CITY OF ALBUQUERQUE

**RE: MDS - Montage Subdivision Unit 7 on Bobby Foster
Grading and Drainage Submittal for Preliminary Plat and Grading Permit
Engineer's Stamp Date: 6/30/22
Hydrology File: R16D100A**

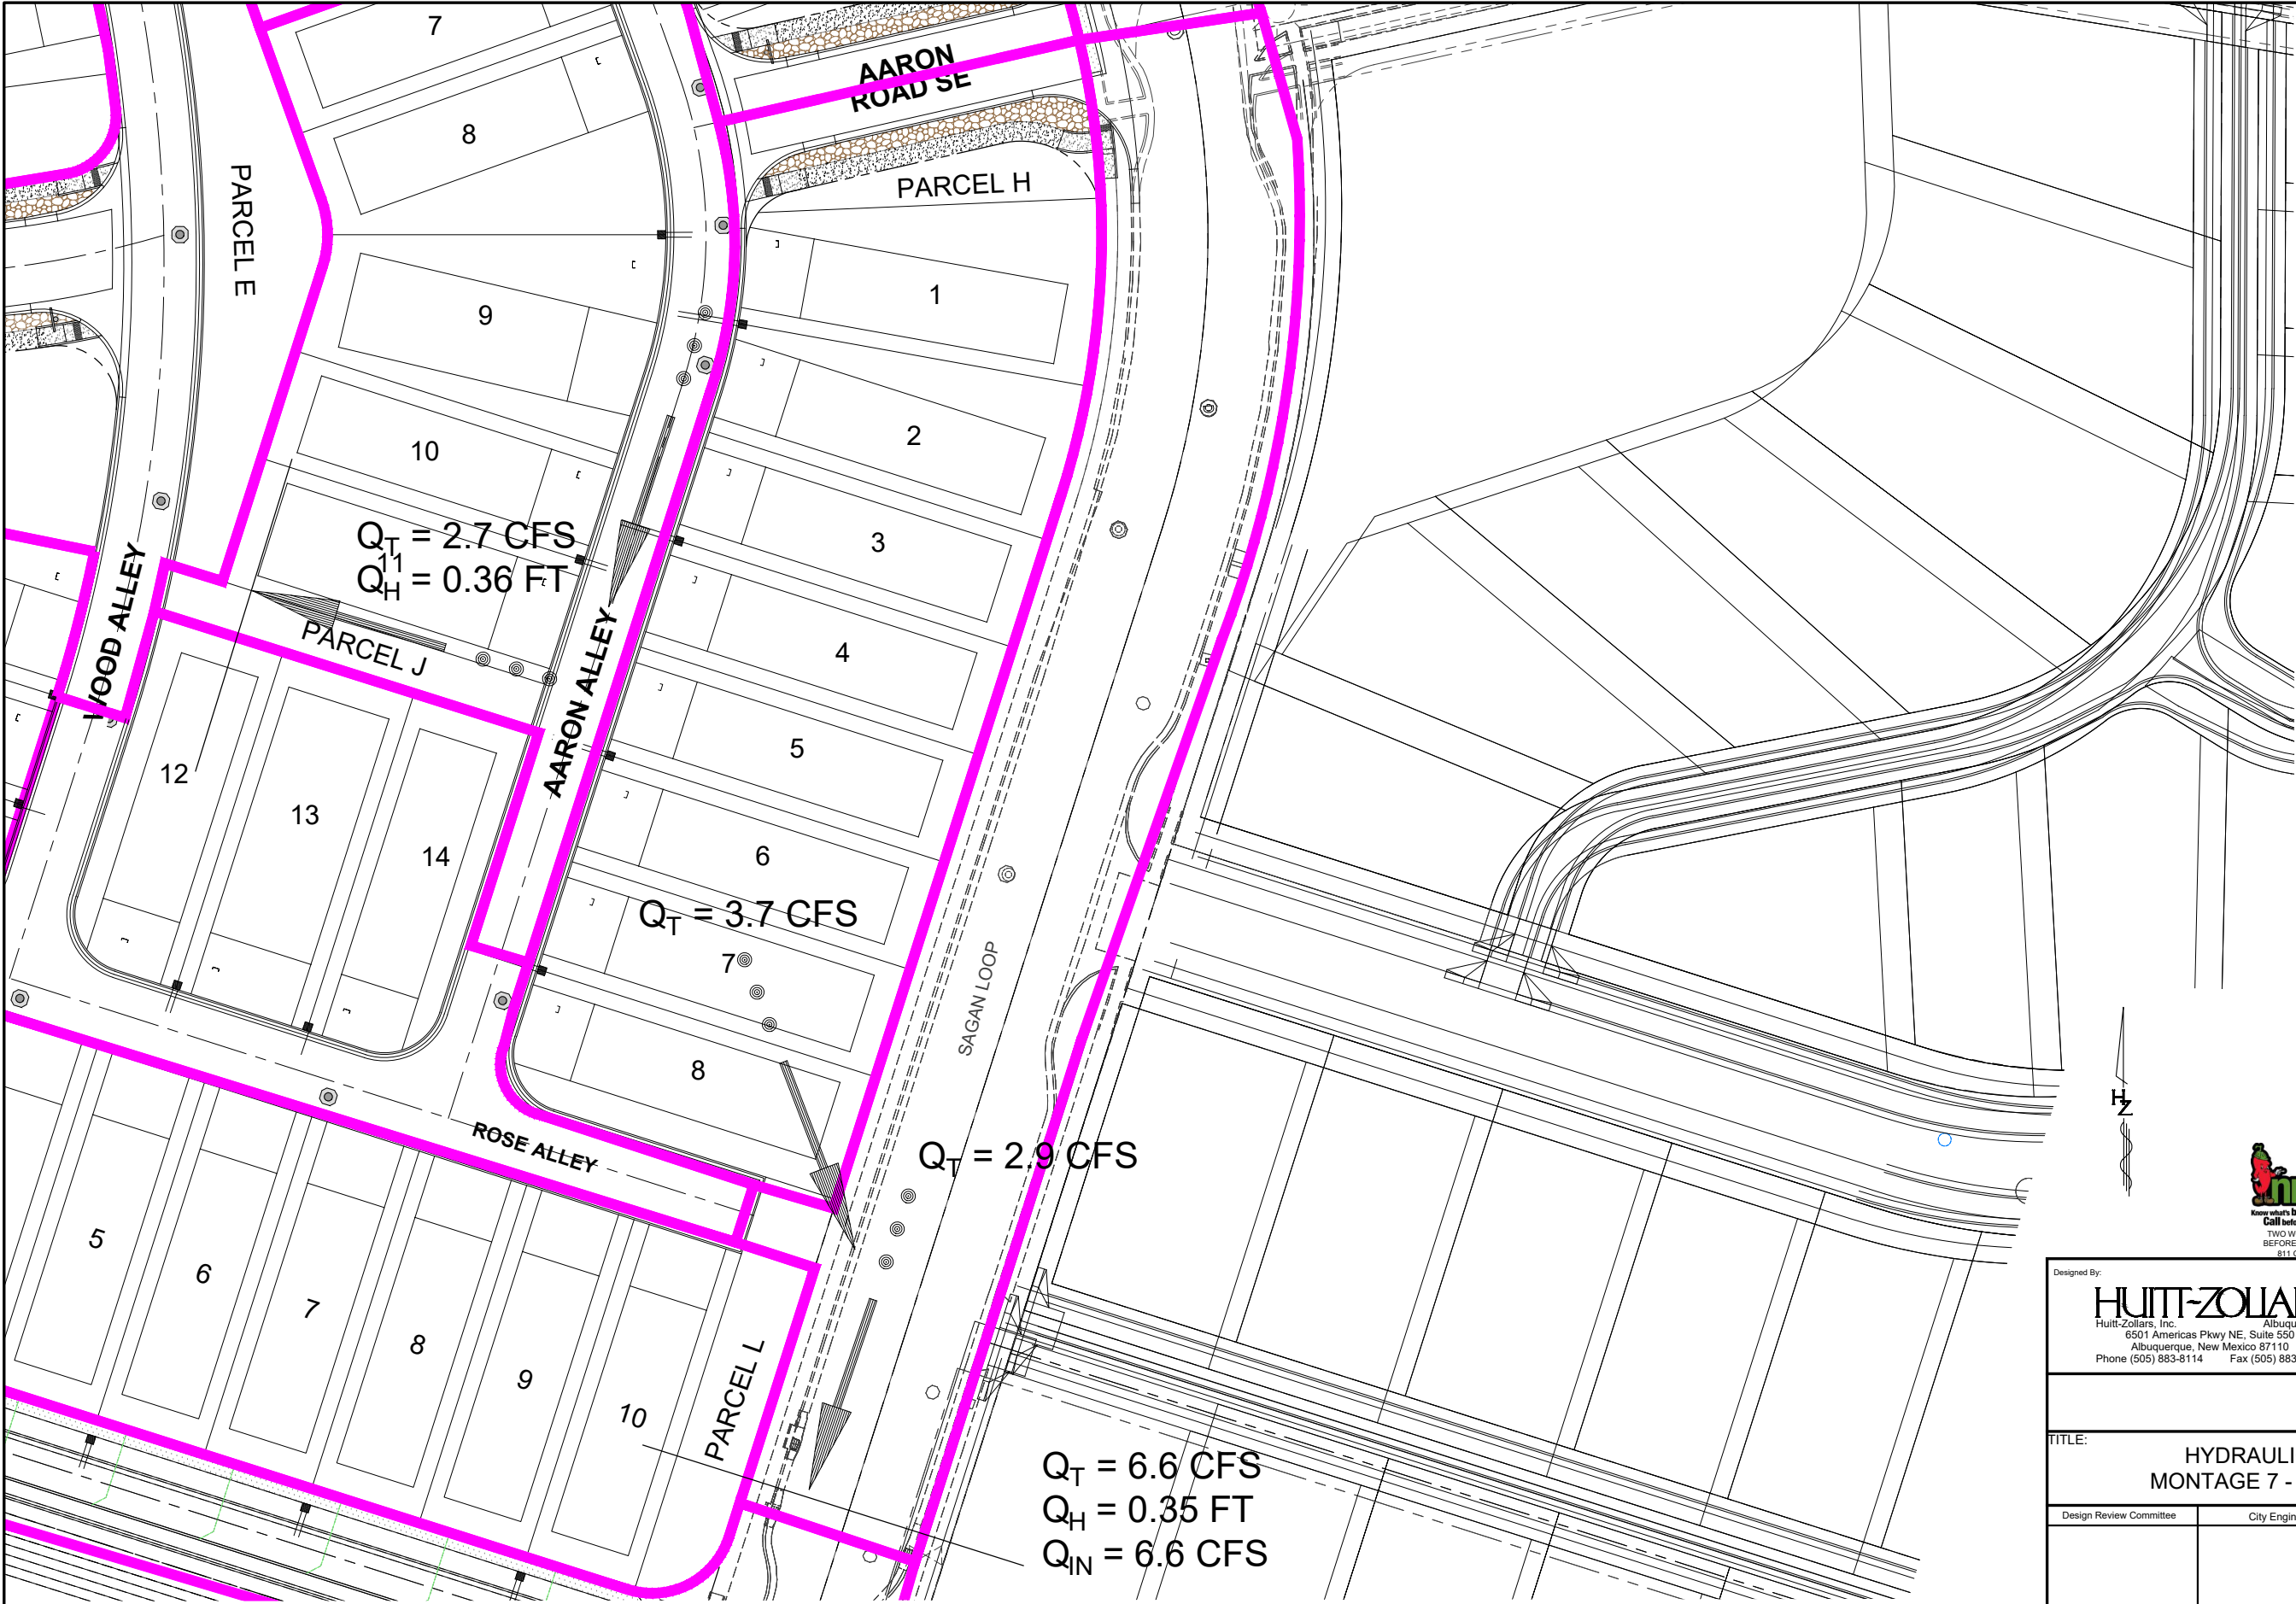
2. The only thing received was a Drainage Report that provided onsite hydrology analysis splitting the site into two large basins. More detailed sub-basin analysis will be required prior to approval of the Infrastructure List (IL) and Preliminary Plat (PP). Proration may be used instead of AHYMO models for each sub-basin.

5. The existing and proposed storm pipes and inlets with sizes and hydraulic analysis were missing from the basin map in the drainage report. The analysis is required prior to approval for this PP.

STORMCAD PROFILES
MONTAGE 7 - MESA DEL SOL

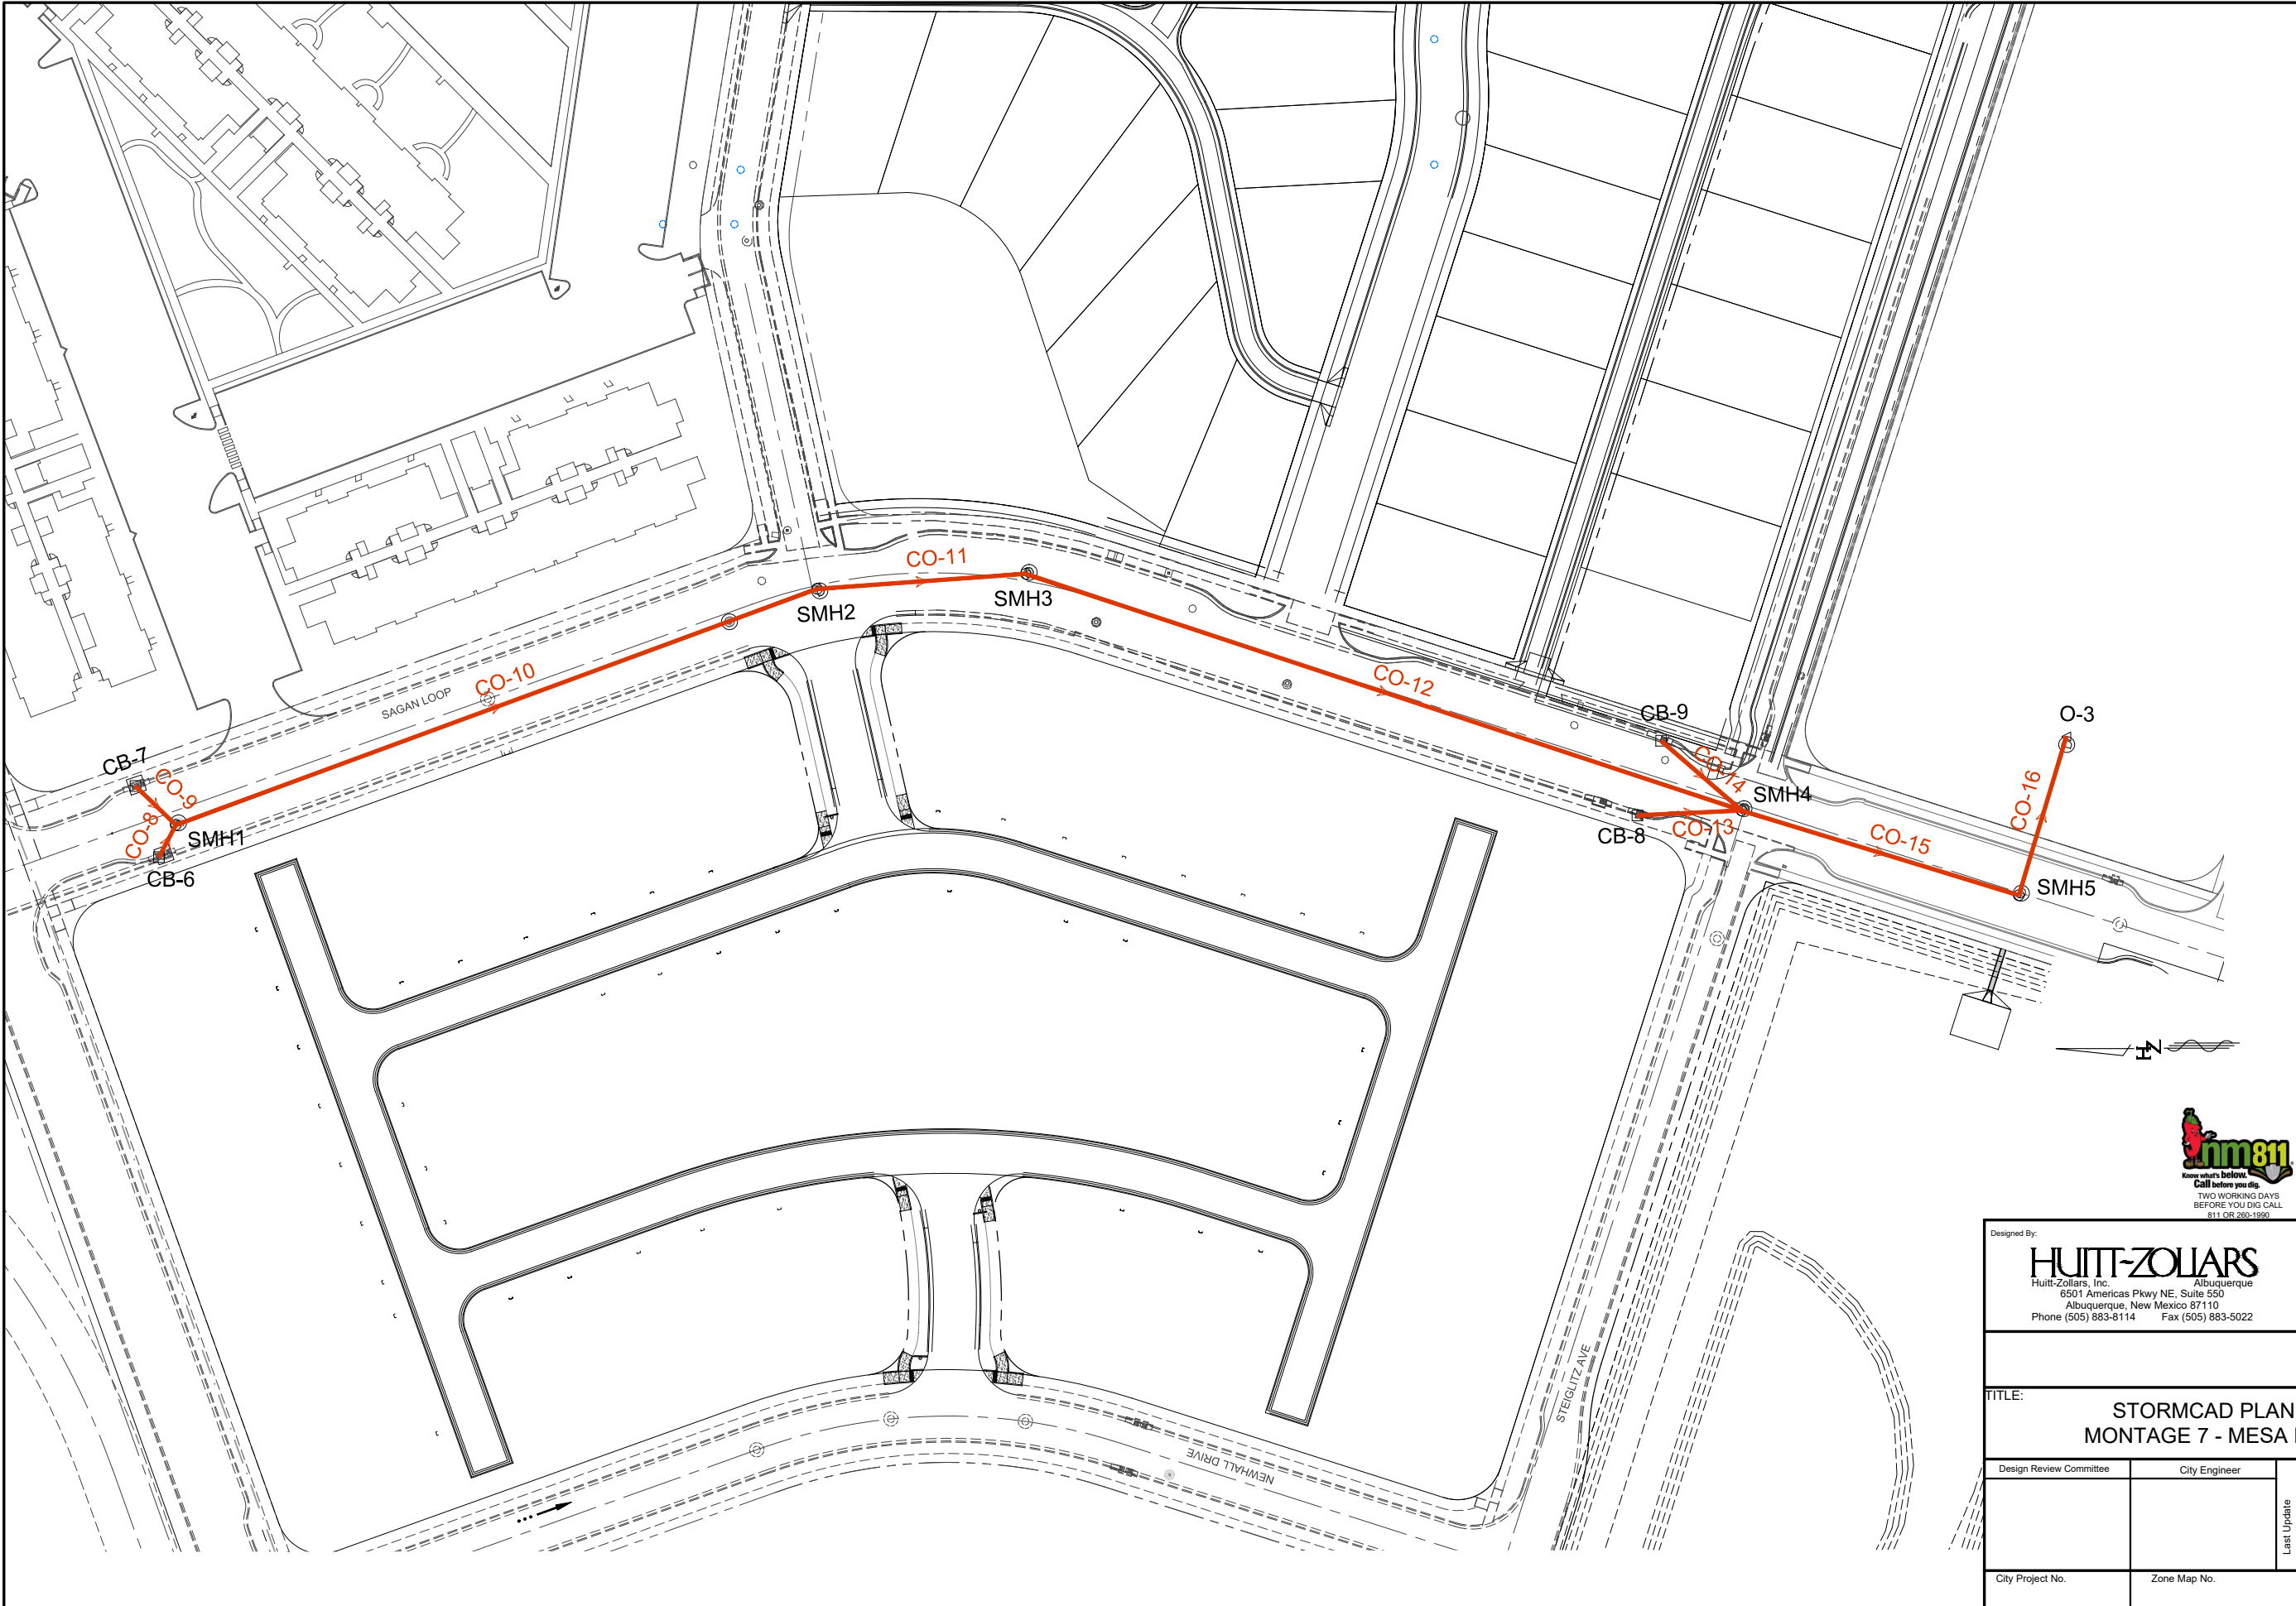
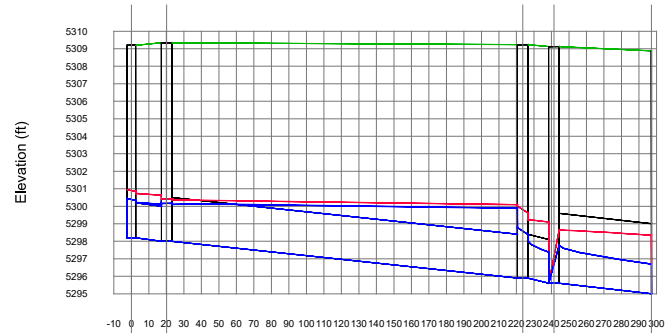
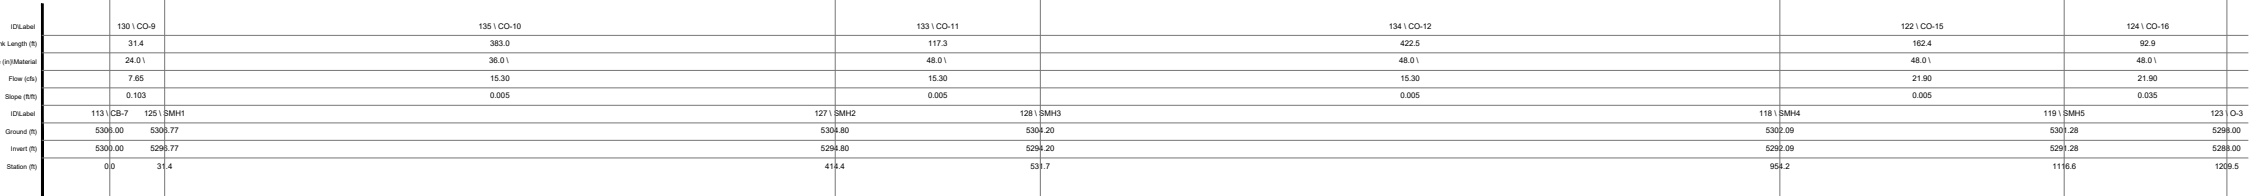
6. Hydraulic grade line calculations and pipe profiles will be required prior to drainage report approval for (WO).
7. Provide surface drainage analysis demonstrating that the 100-year HGL remains at/below top of curb, and the 100-year EGL remains within the ROW for the onsite streets and alleys and the adjacent streets that receive drainage from this site. The report has only one surface analysis (for a 32' street at 0.5% slope with 6" curbs, gutter depression is missing and location is missing). Identify the location of each analysis point and account for the effects of local gutter depression.
